Your ref: 3/2013/0568
Our ref: DC/13/2607
Date: 22-JUL-13

Location: Land Adjacent 10 Whalley Road, Mellor Brook, Blackburn
Proposal: Erection of one dwelling

title	Site Layout & Sections
-------	------------------------

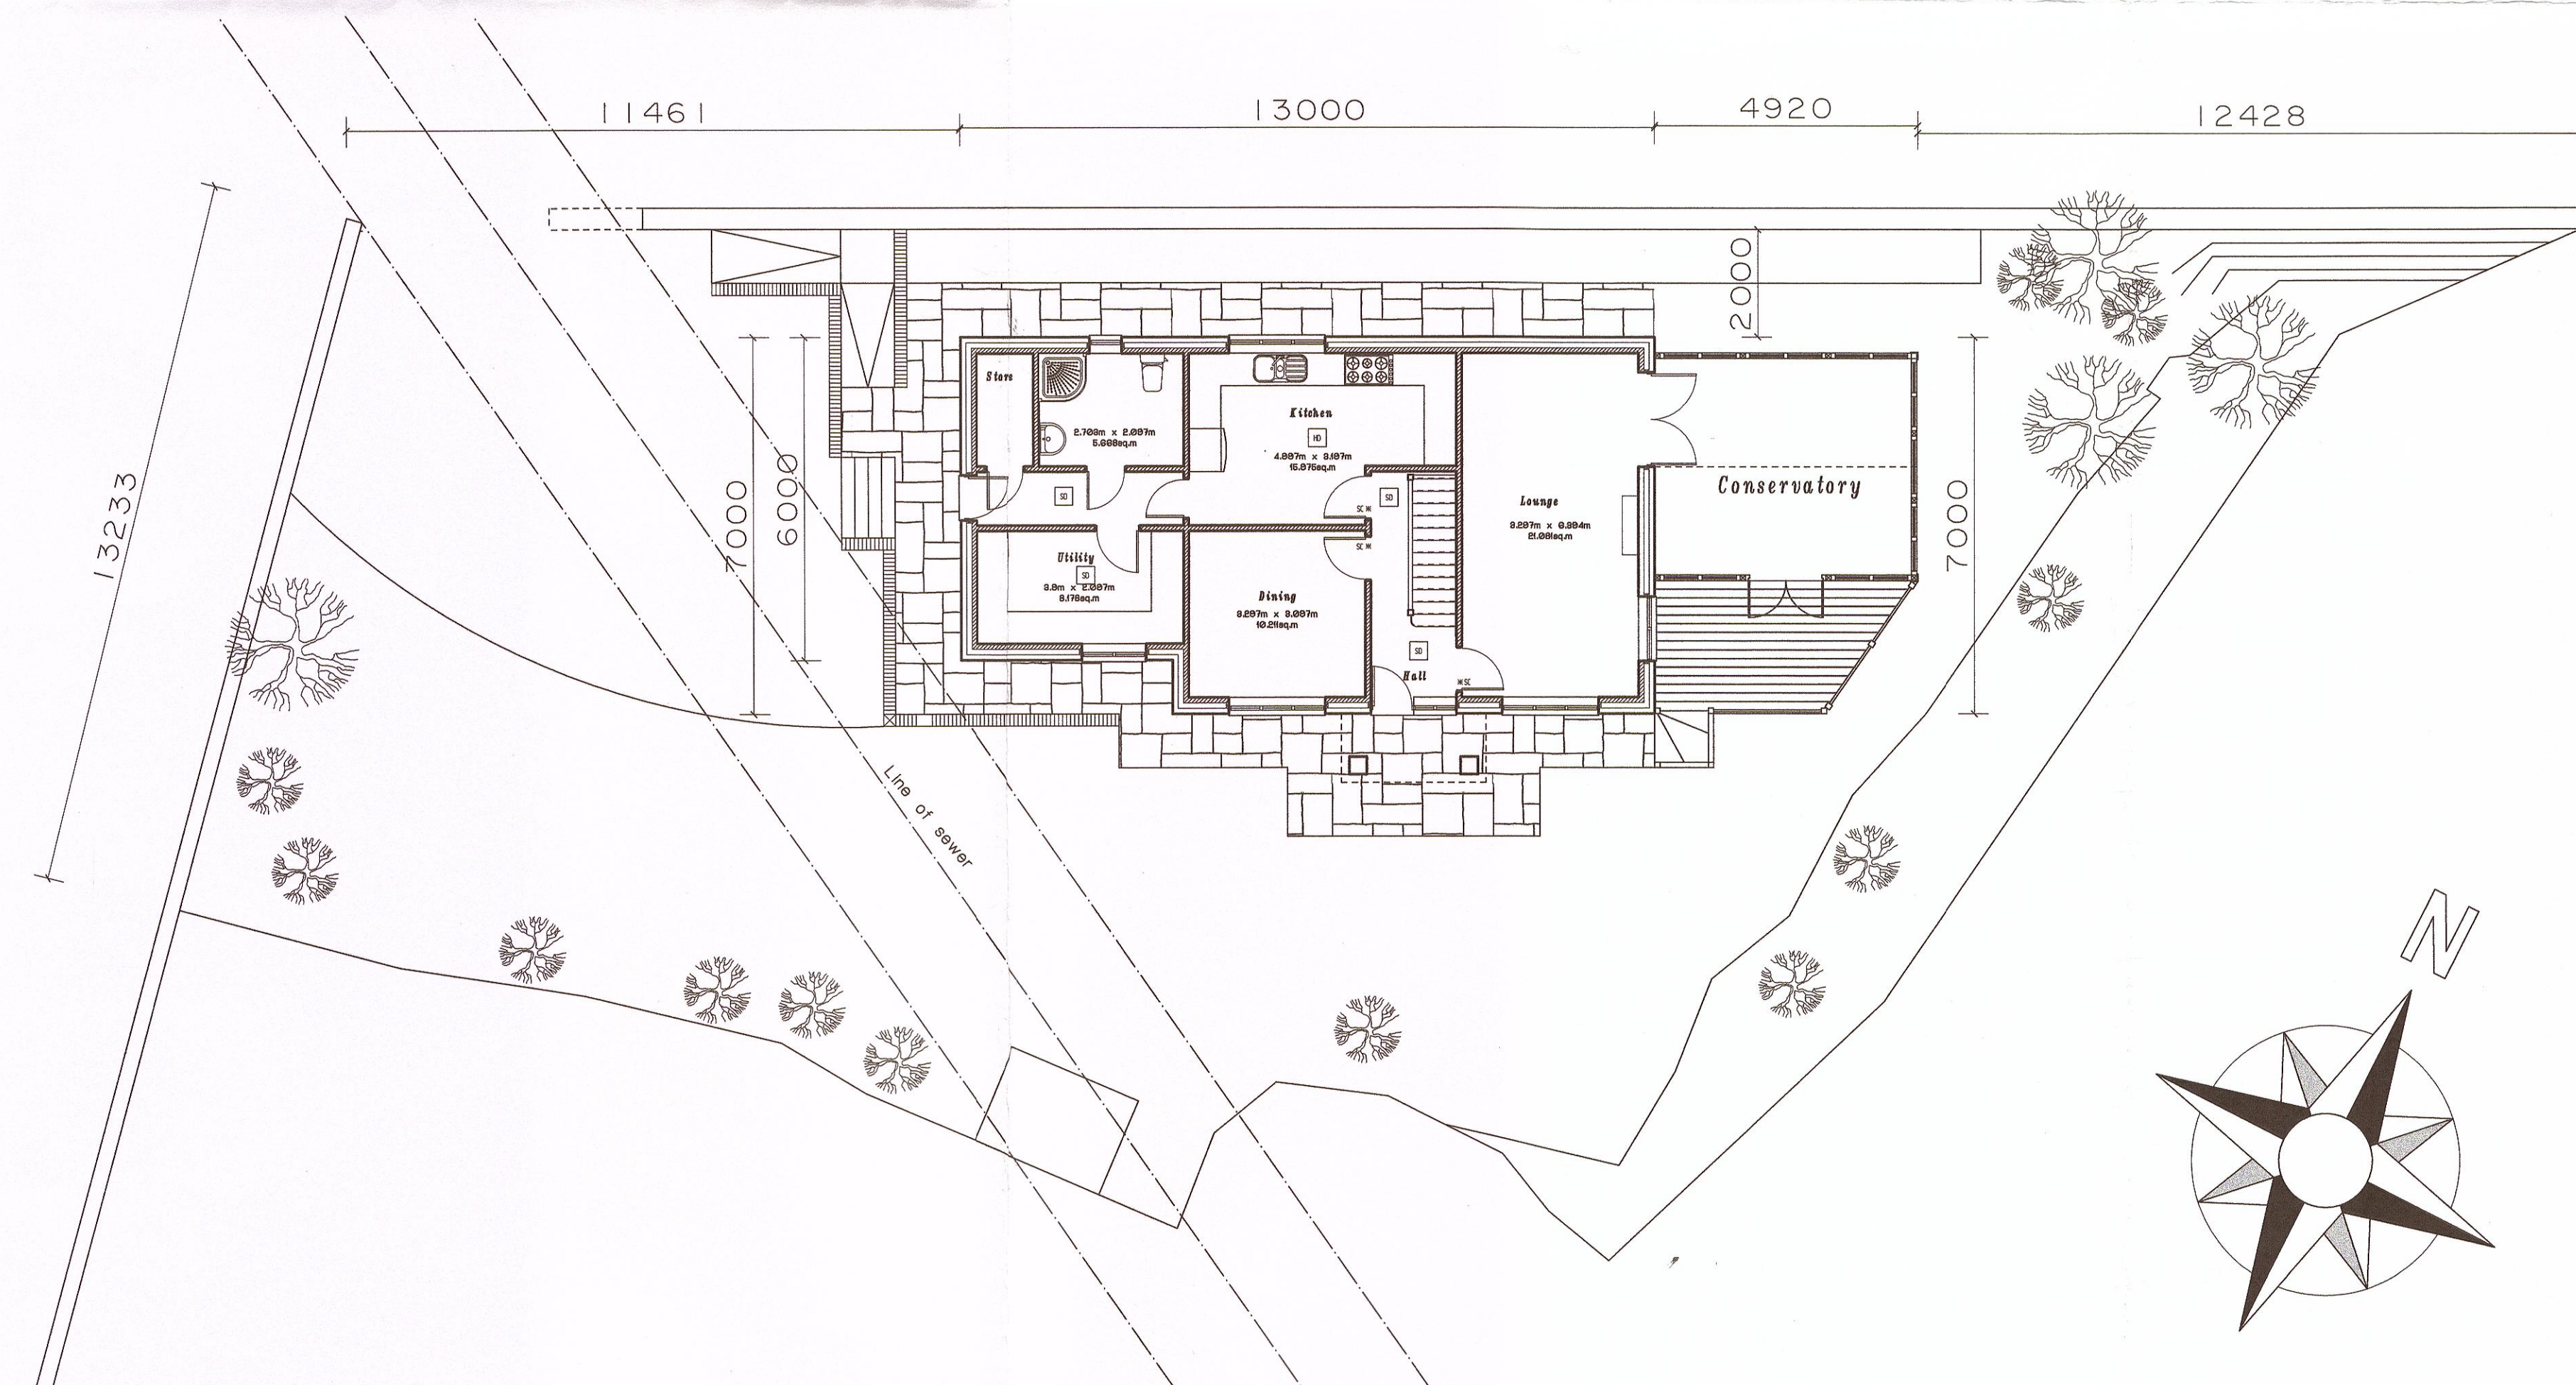
A public sewer crosses this site and we will not permit building over it. We will require an access strip width of 6 metres, 3 metres either side of the centre line of the sewer which is in accordance with the minimum distances specified in the current issue of "Sewers for Adoption", for maintenance or replacement.

The development plan is quite vague but it does appear that the new dwelling would cross a sewer about which I would advise you speak to networks as the sewer is not protected by a formal easement. The developer may wish to enter into a Building Over Agreement for which they would need to contact the Legal Dept.

- Unless otherwise agreed in writing by the Local Planning Authority, no building shall be erected within 3 metres of any existing public sewer.
